REF: EN010147 Botley West Solar Farm Representation: Feedback to PVDP Change

Further to my first submission on 5th June, I would like to feedback on the proposed PVDP change proposal.

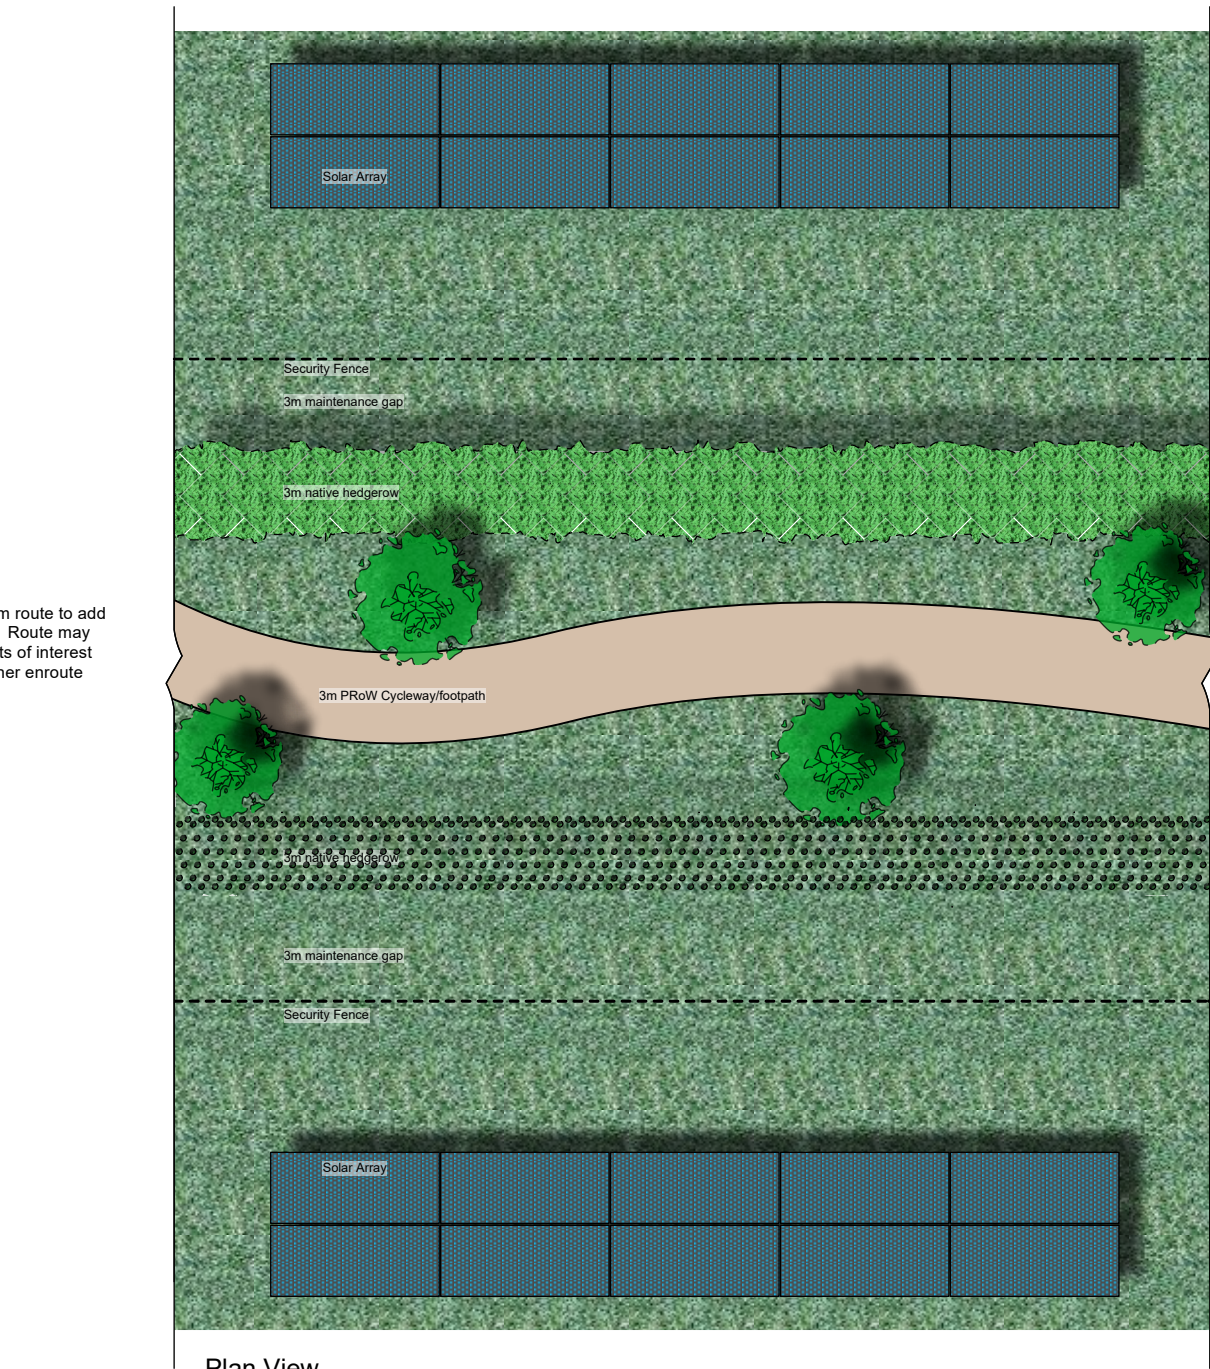
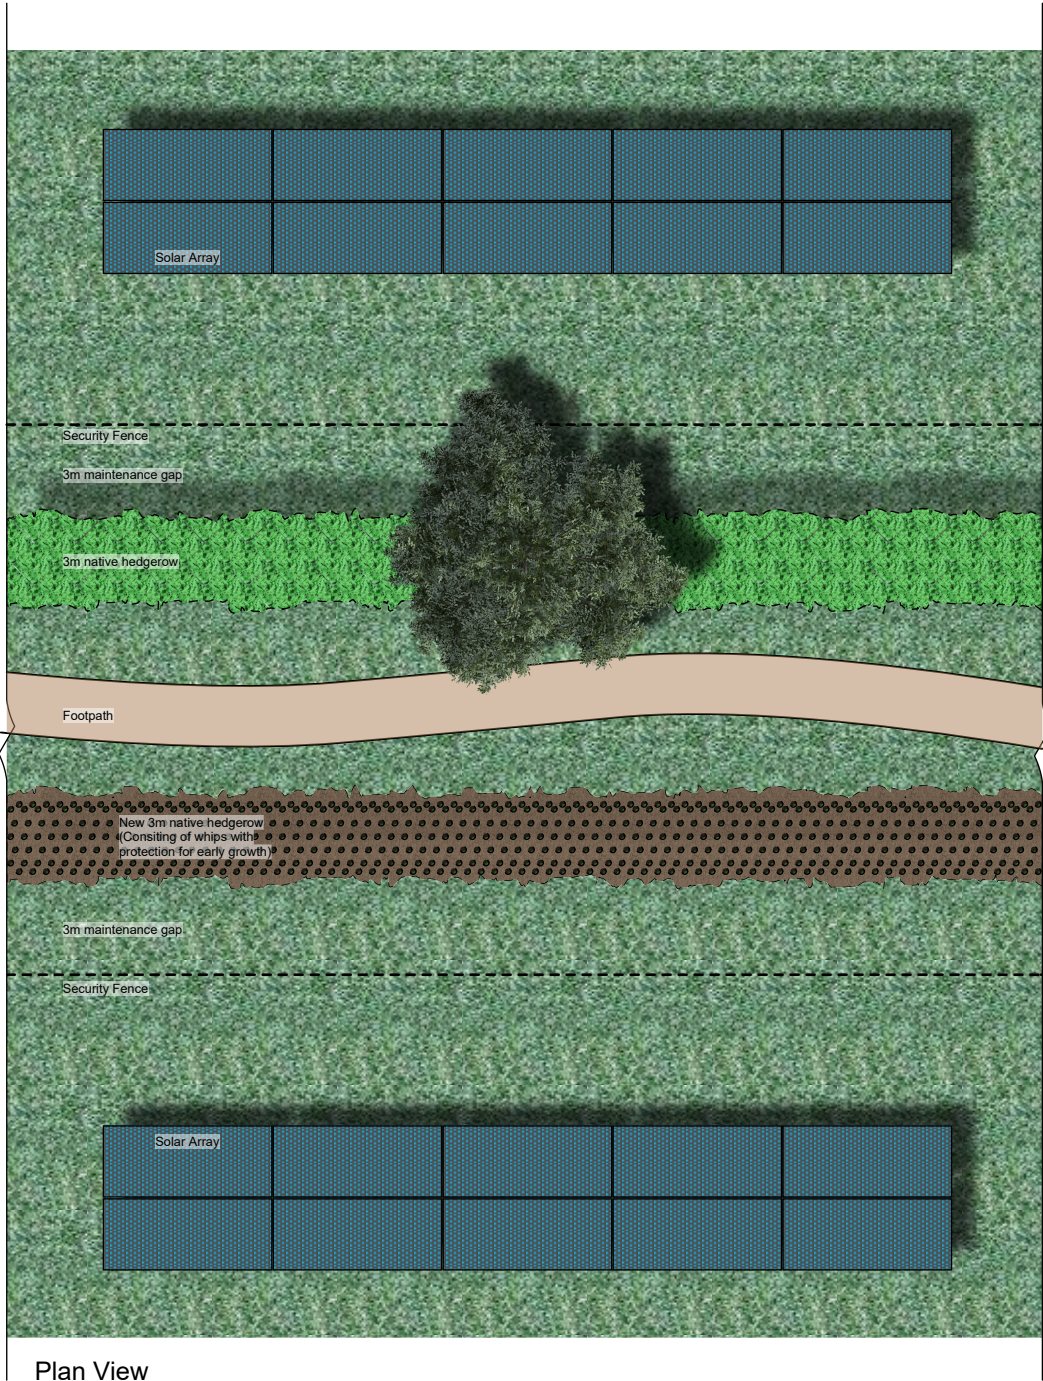
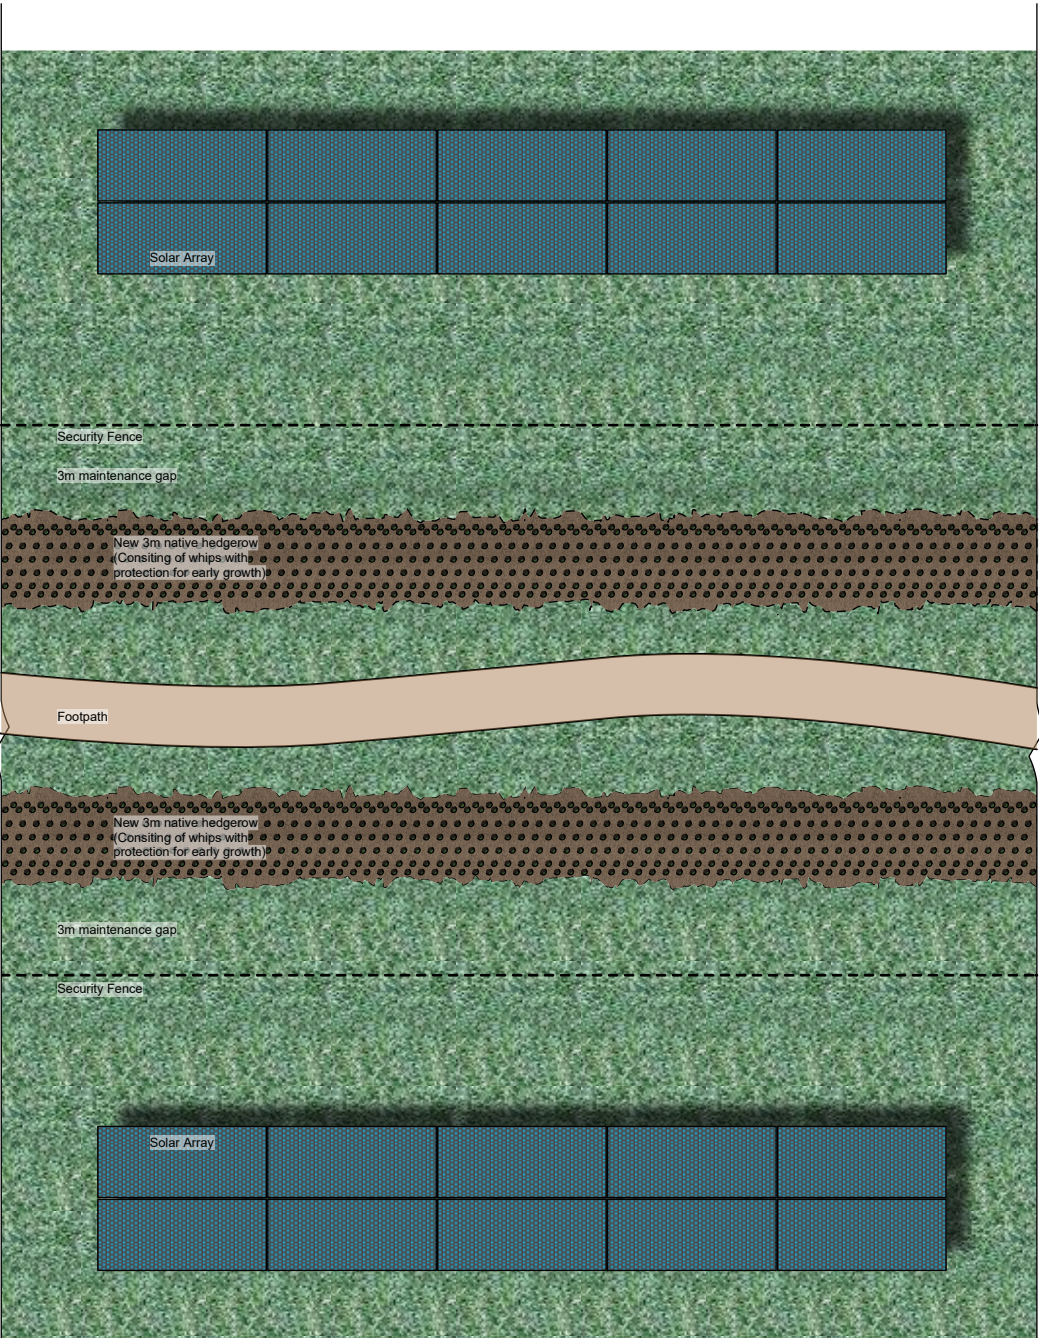
3. I have concerns over the interpretation of Hedges and Footpaths. There is concern over the size of the hedges being proposed. Any hedgerow must be in line with the local environment and not overly oppressive and should not exceed 2m. Footpaths and bridleways should not be overwhelmed by high hedges. (ExQ2.13.8, and responses from all IPs to this question)
